Submissions Received after the Close of the Examination

TR010043

Great Yarmouth Third River Crossing

APPLICATION BY NORFOLK COUNTY COUNCIL FOR AN ORDER GRANTING DEVELOPMENT CONSENT FOR THE GREAT YARMOUTH THIRD RIVER CROSSING PROJECT. RULE 17. REQUEST FOR FURTHER INFORMATION, DEADLINE 8.

DRAWN	CHECKED	APPROVED	AUTHORISED
AK	JW	TJ	MK

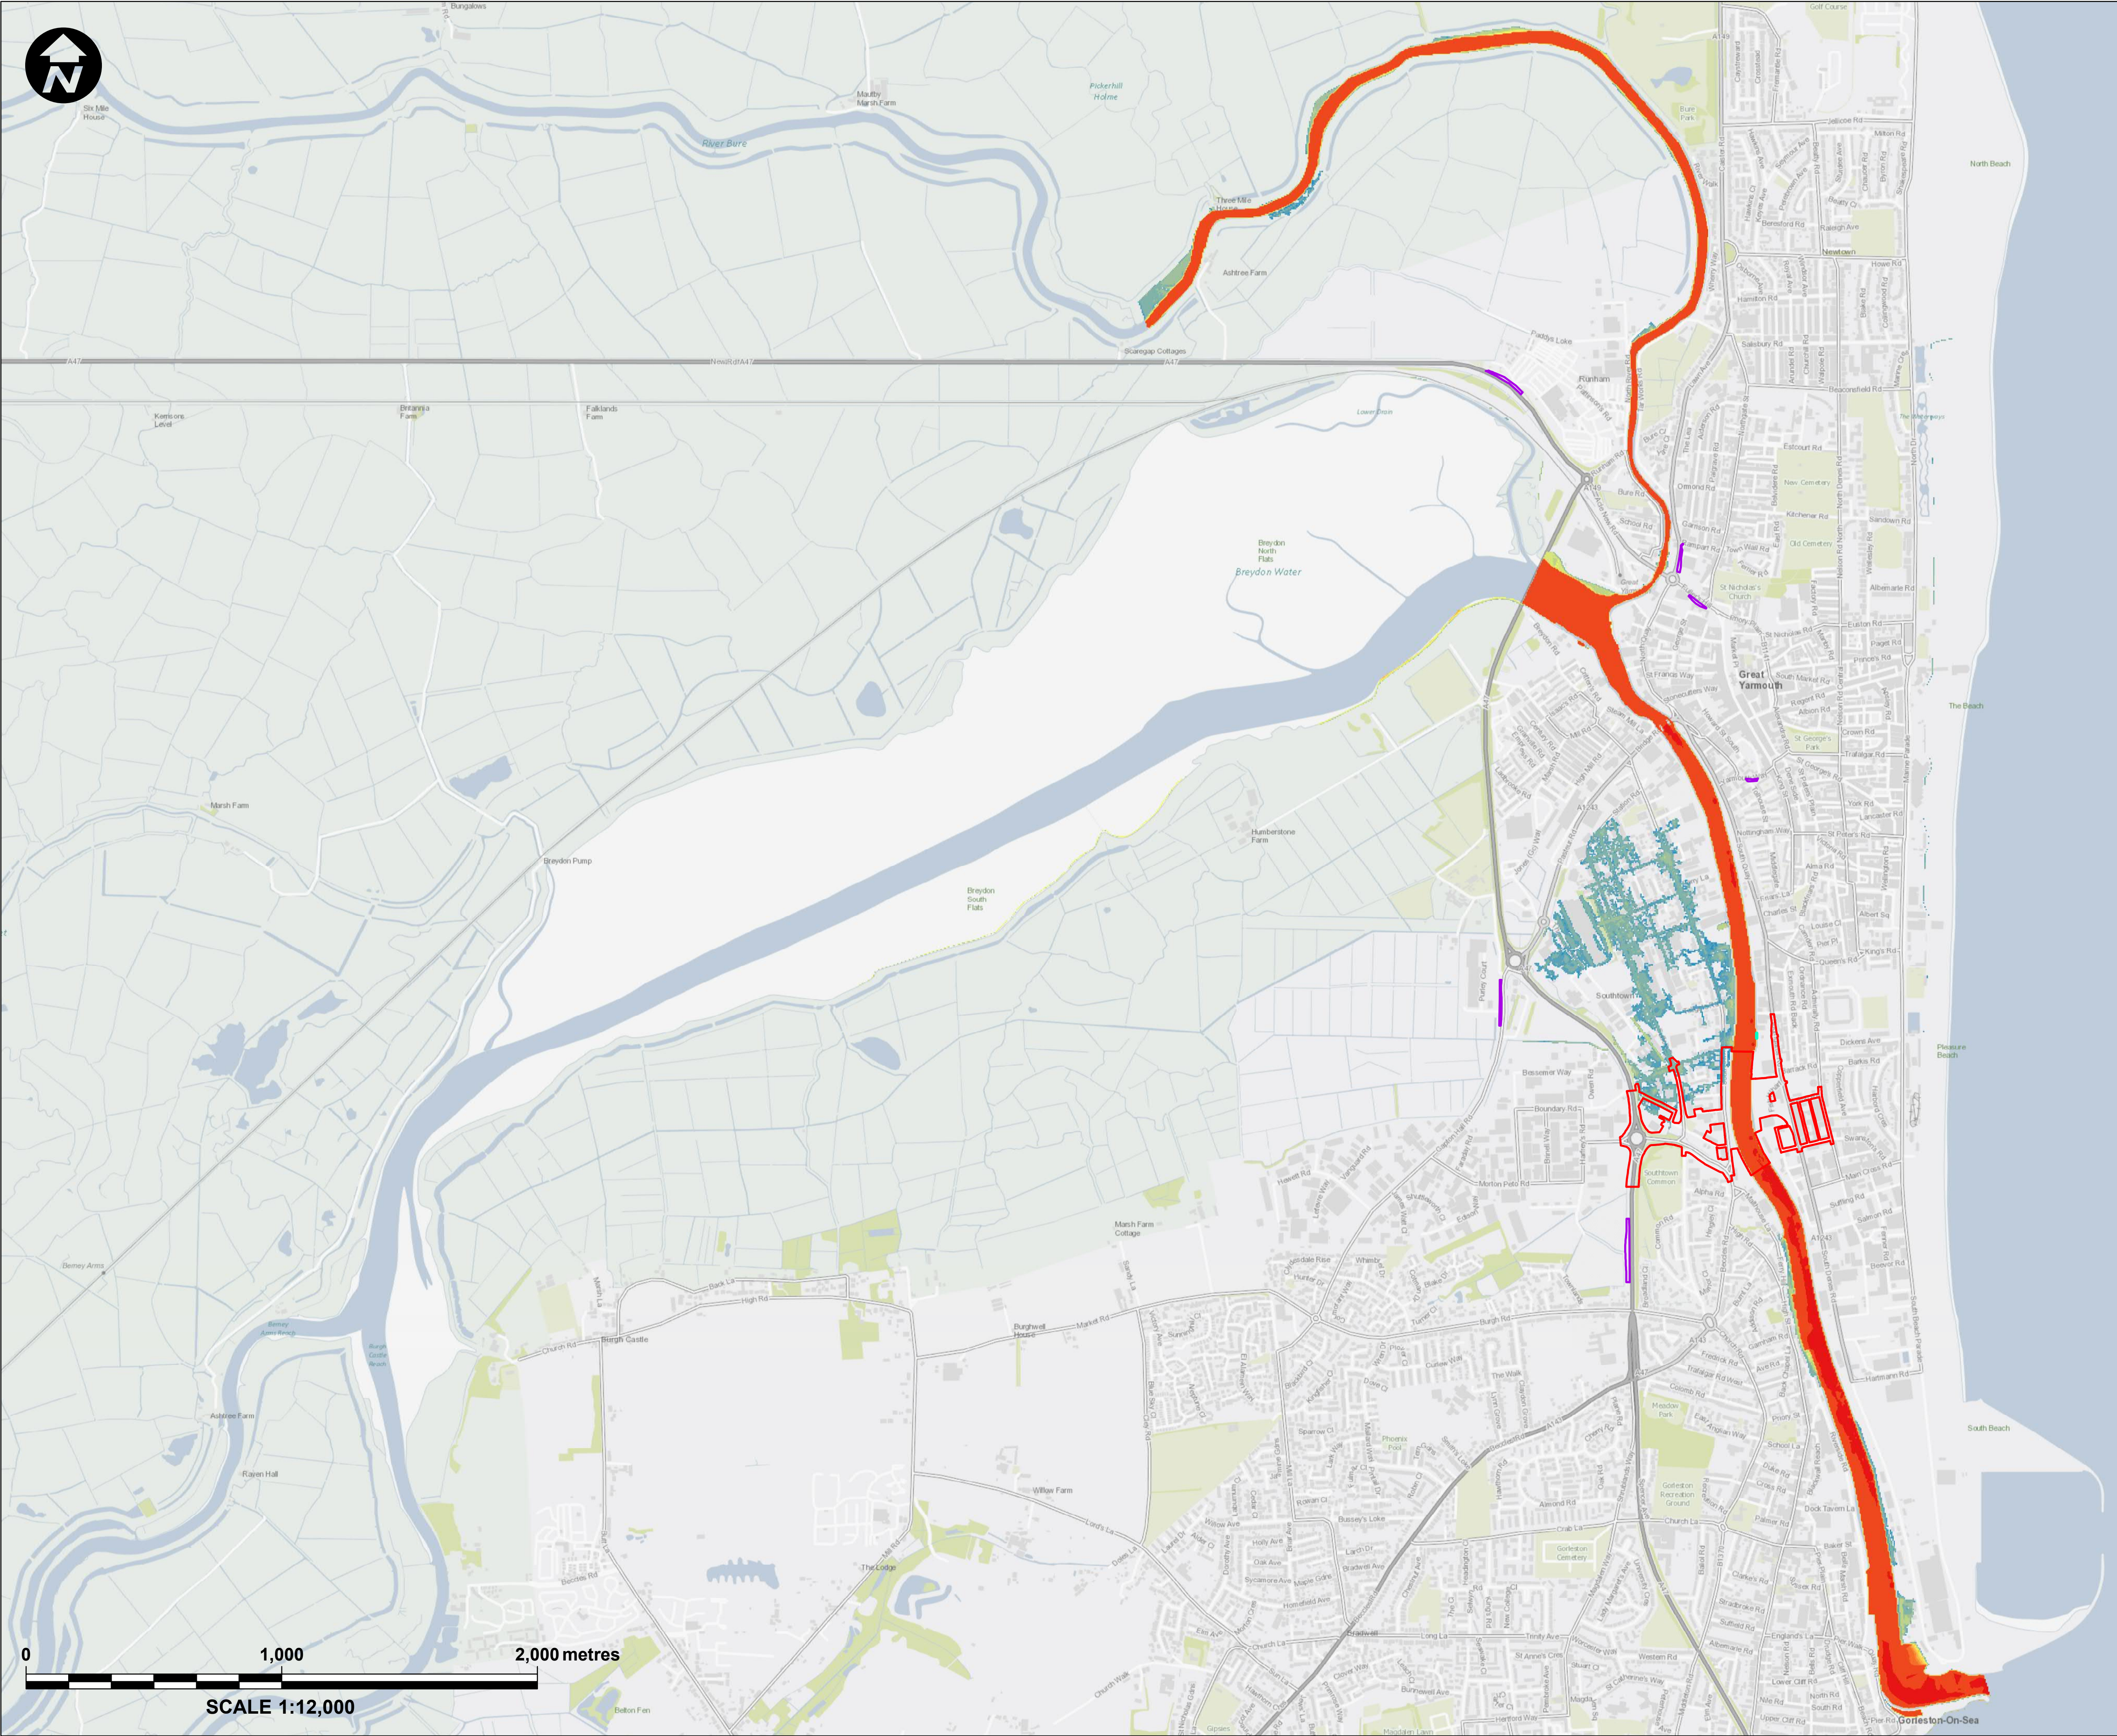
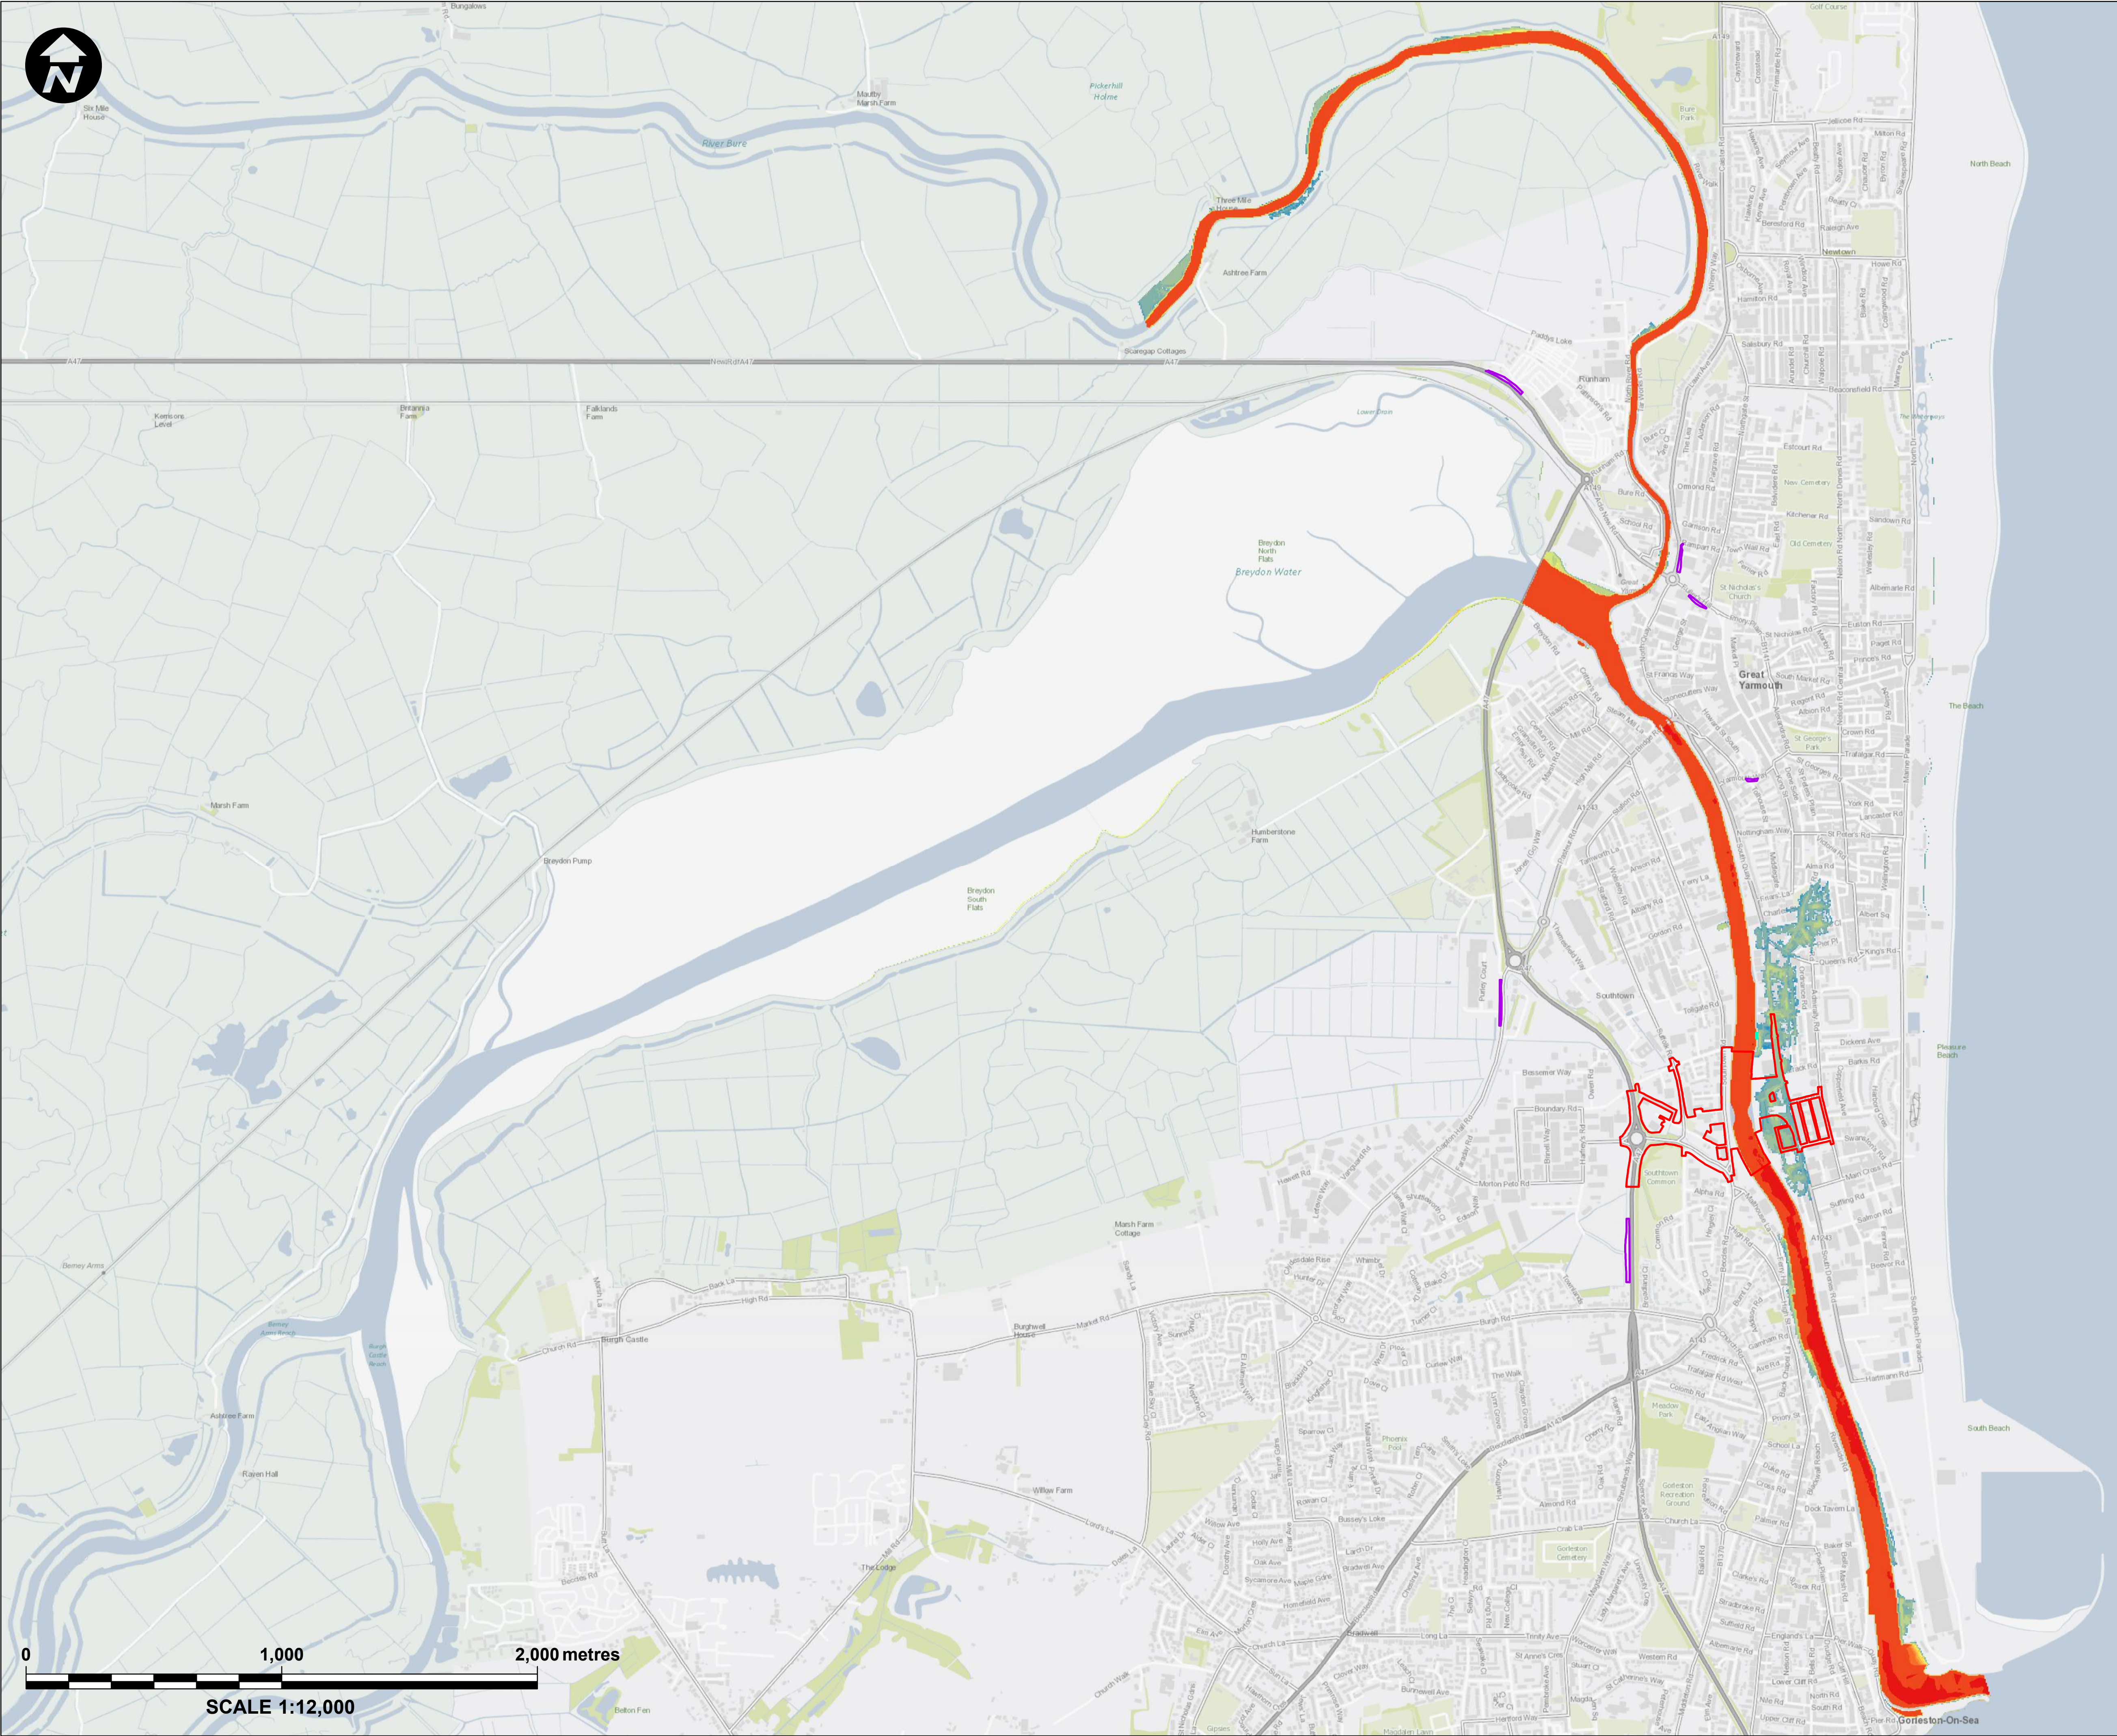
We consider that although the submitted data does not present the fullest picture of the impacts of the proposed development on third parties, and specifically residential properties; it does provide the Examining Authority with sufficient information to make a judgement on flood depths, flood velocities and flood hazard in the areas of additional flood extent in the event of a breach occurring.

We consider that best practice is to provide figures/maps showing the difference in flood depths over the whole flood extent with the bridge infrastructure in situ and not only the superimposed differences on the current day baseline flood extents. The existing figures show the depth of flooding in the event of a breach scenario and are shown alongside the baseline of no bridge we feel that the existing depth difference figures do not show the change in flood depth in additional areas of flood extent that occur as a consequence of the bridge structure being in situ (these areas would previously have been dry). We do, however, note that the ExA may view the flood depth information for those additional inundated areas by looking at the individual flood depth maps.

Additional information in respect of the tidal residual breach analysis was supplied by the Applicant on 19 March 2020. Following review I am able to confirm that the information satisfies Environment Agency concerns; as such our objection to the DCO is withdrawn.
